File No: R/2015/15/A
Our Ref: 2016/485380

RE: SSD 7037 – Mixed Use Development, 75-85 Harrington Street, The Rocks

The City has had an opportunity to review the proposal and wishes to convey its **objection** to the proposal.

Plans
Basement Level 1

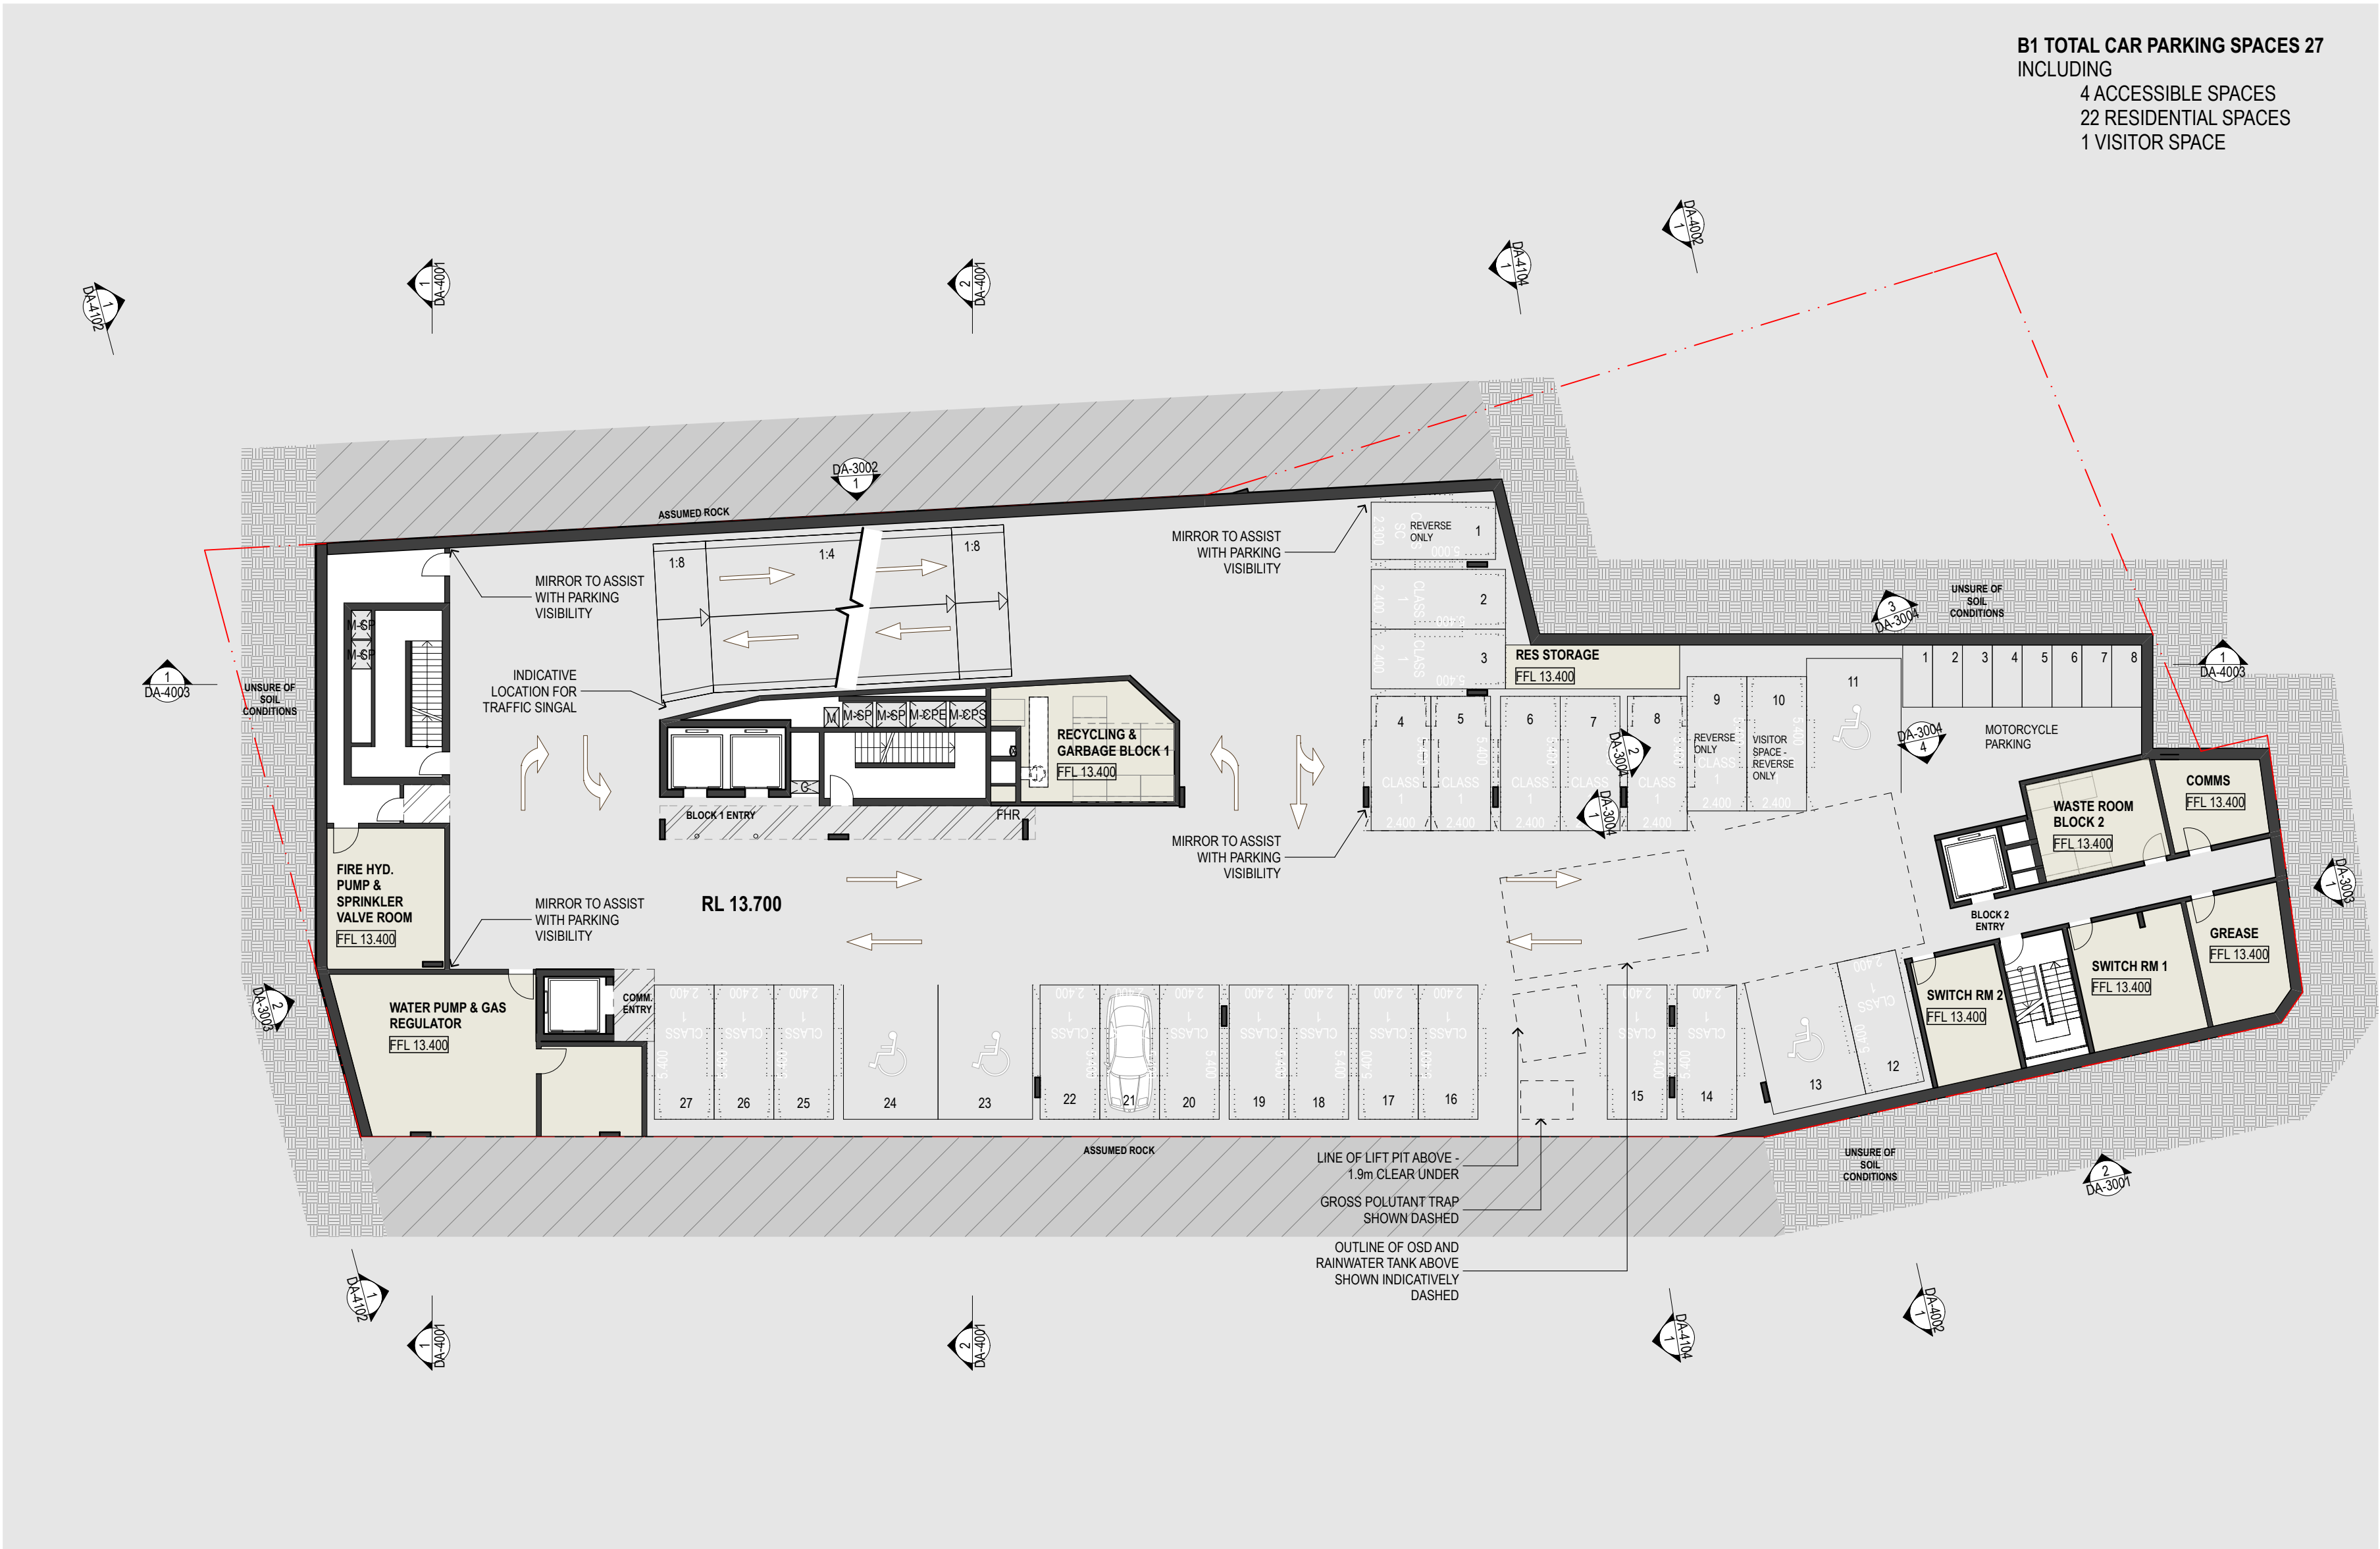
The design of the basement car park should comply with AS/NZS 2890 and Council's DCP. It is noted that there are a number of non-compliances in this regard including:

- Accessible parking spaces do not comply with AS/NZ 2890.6.

- Parking spaces that require “reverse in only” do not provide the 1m end of aisle clearance required by AS/NZS 2890.1
- Swept path movements adjacent to ramps and aisle turns show that manoeuvring does not work.

TITLE
Plans
Ground Floor Plan (Harrington Street)

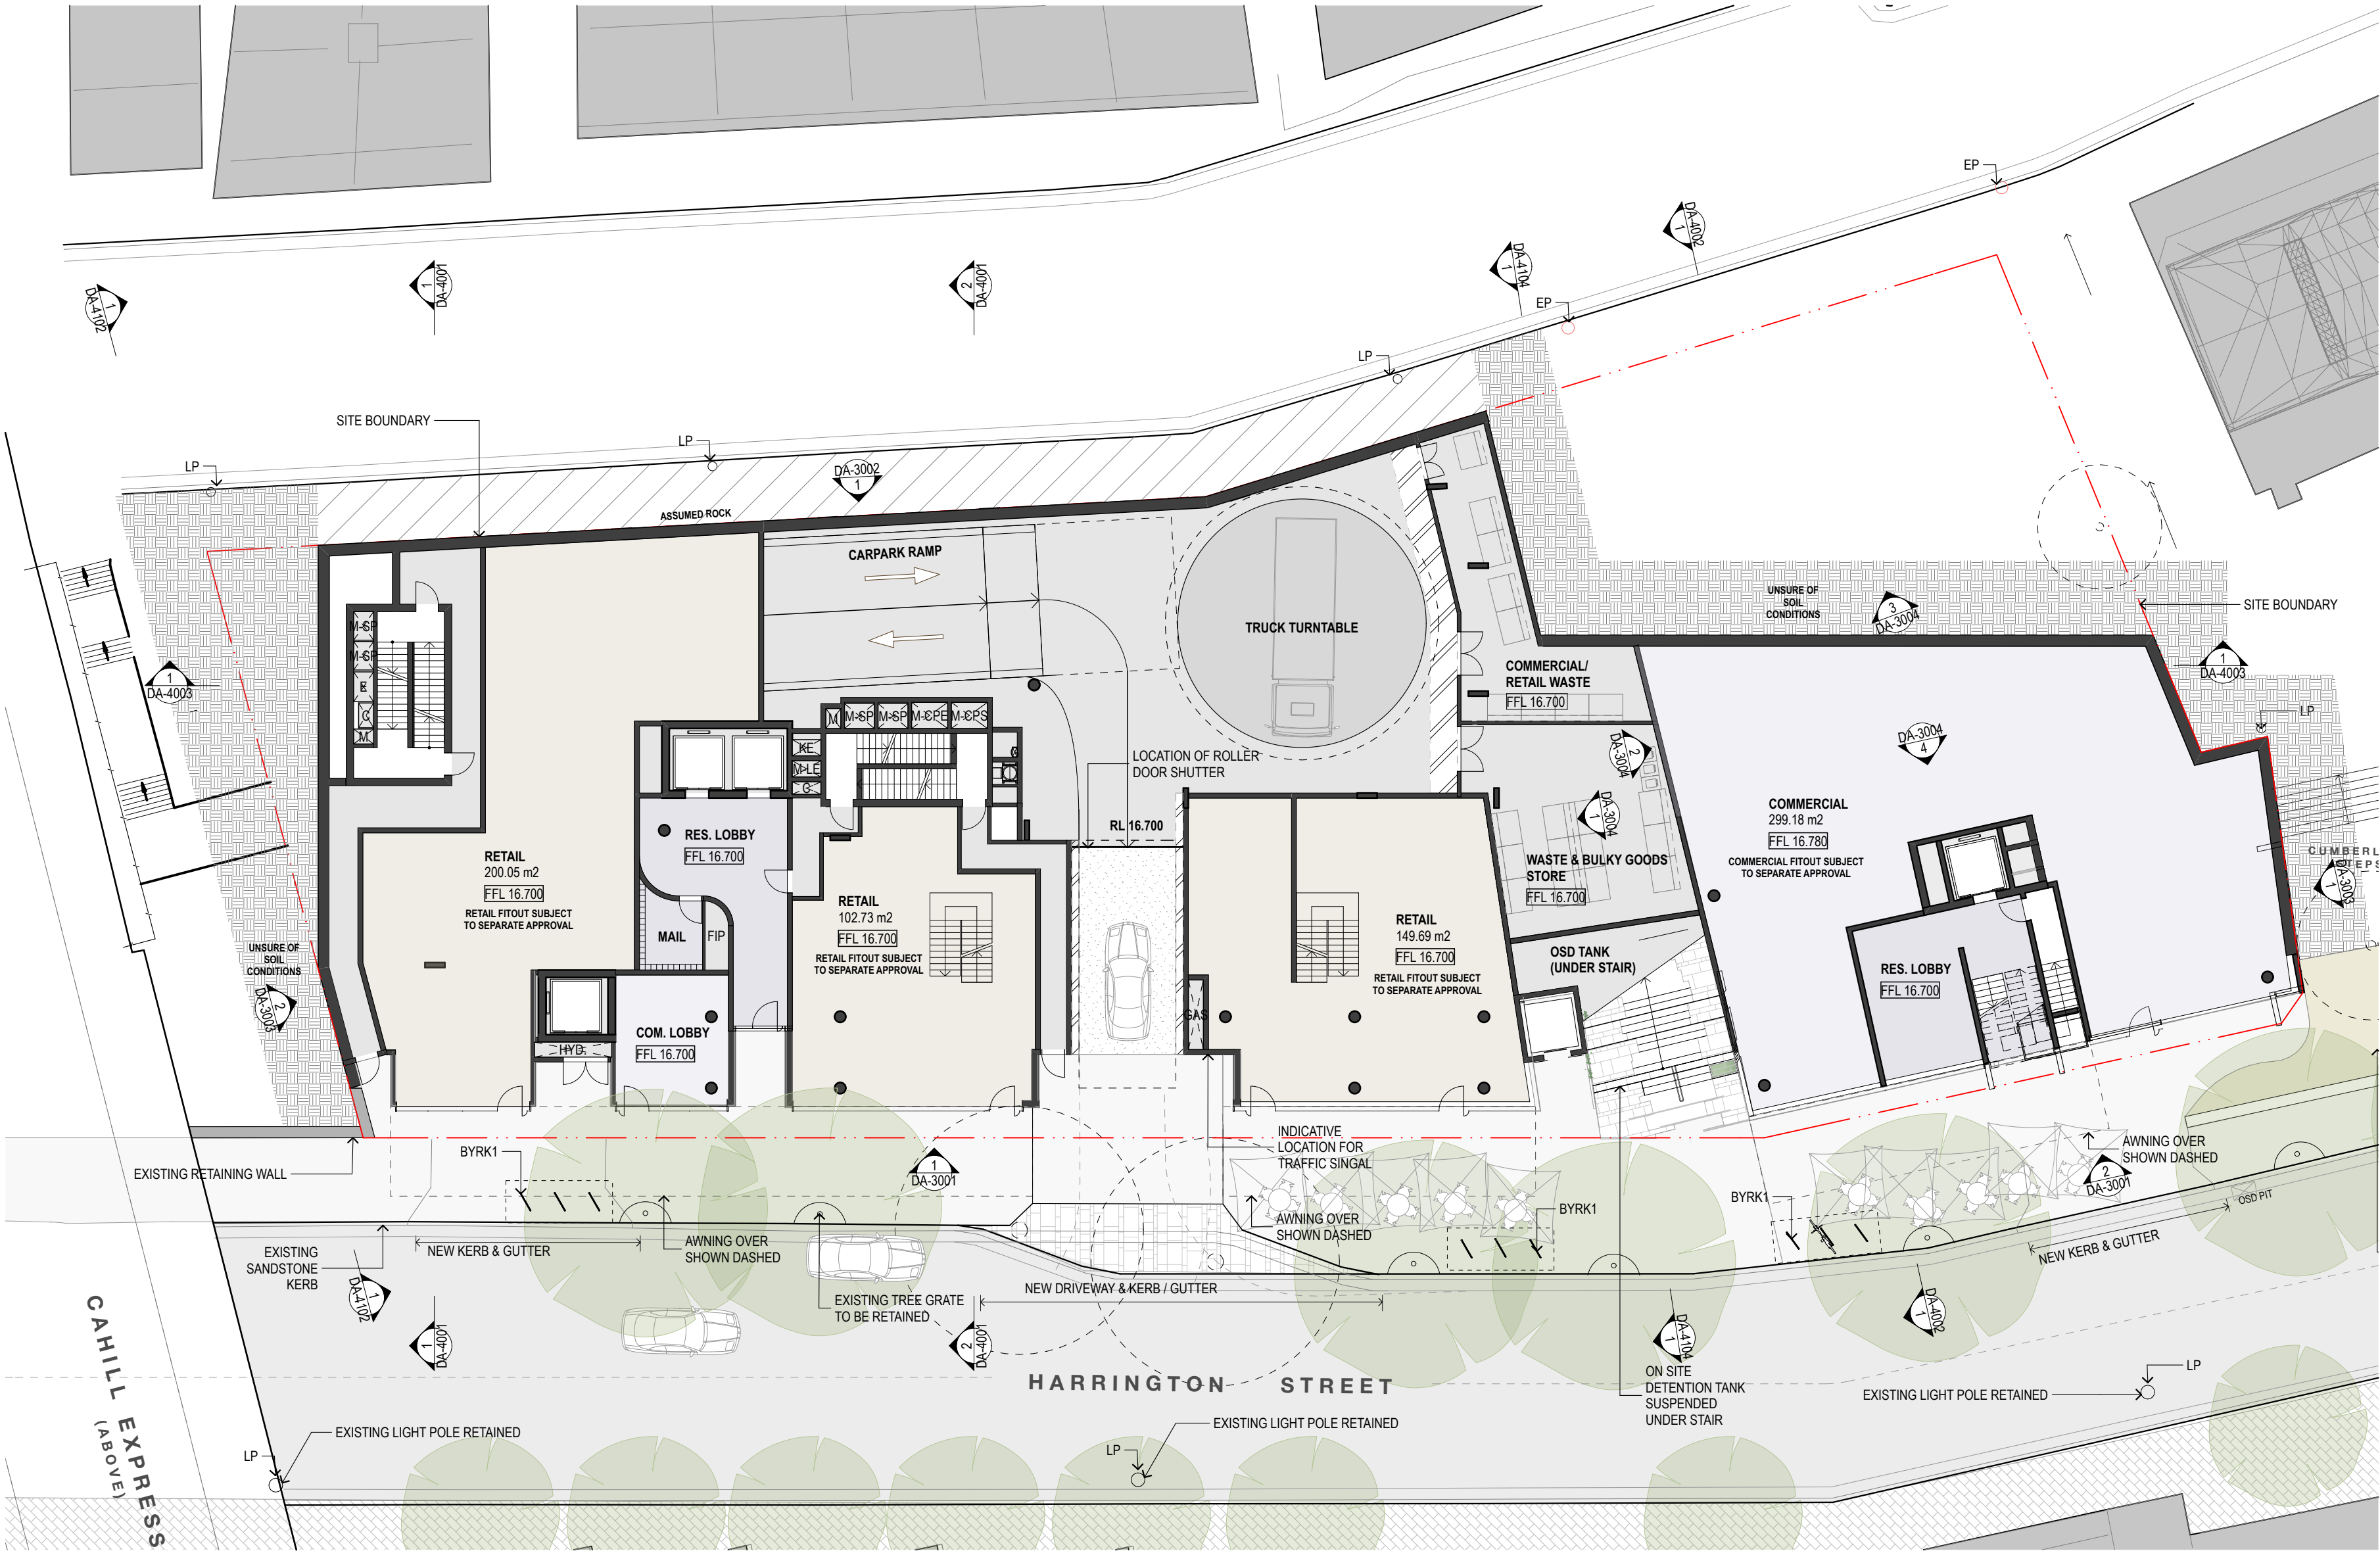
The design of the loading dock facility is insufficient to accommodate the service needs of the site. The dock has been designed for a 6.4m small rigid vehicle (SRV). It does not accommodate access for a residential waste collection vehicle or residential removalist trucks. It is questionable that one SRV space is sufficient for the needs of the commercial and retail tenancies proposed. The City will not support the use of public on-street spaces for the servicing needs of the site.

In addition to the redesign of the loading dock to handle waste collection vehicles and medium rigid vehicles, a loading dock management plan is required.

A swept path analysis needs to be undertaken and the driveway must be designed to accommodate a 9.25m Council waste vehicle for the loading dock.

The residential lobby for Block 1 is an alcove at the footpath interface and should be redesigned to remove the obvious crime prevention through environmental design (CPTED) issues this generates. A limited indent is desired. The glass line of the lobby should be brought forward.
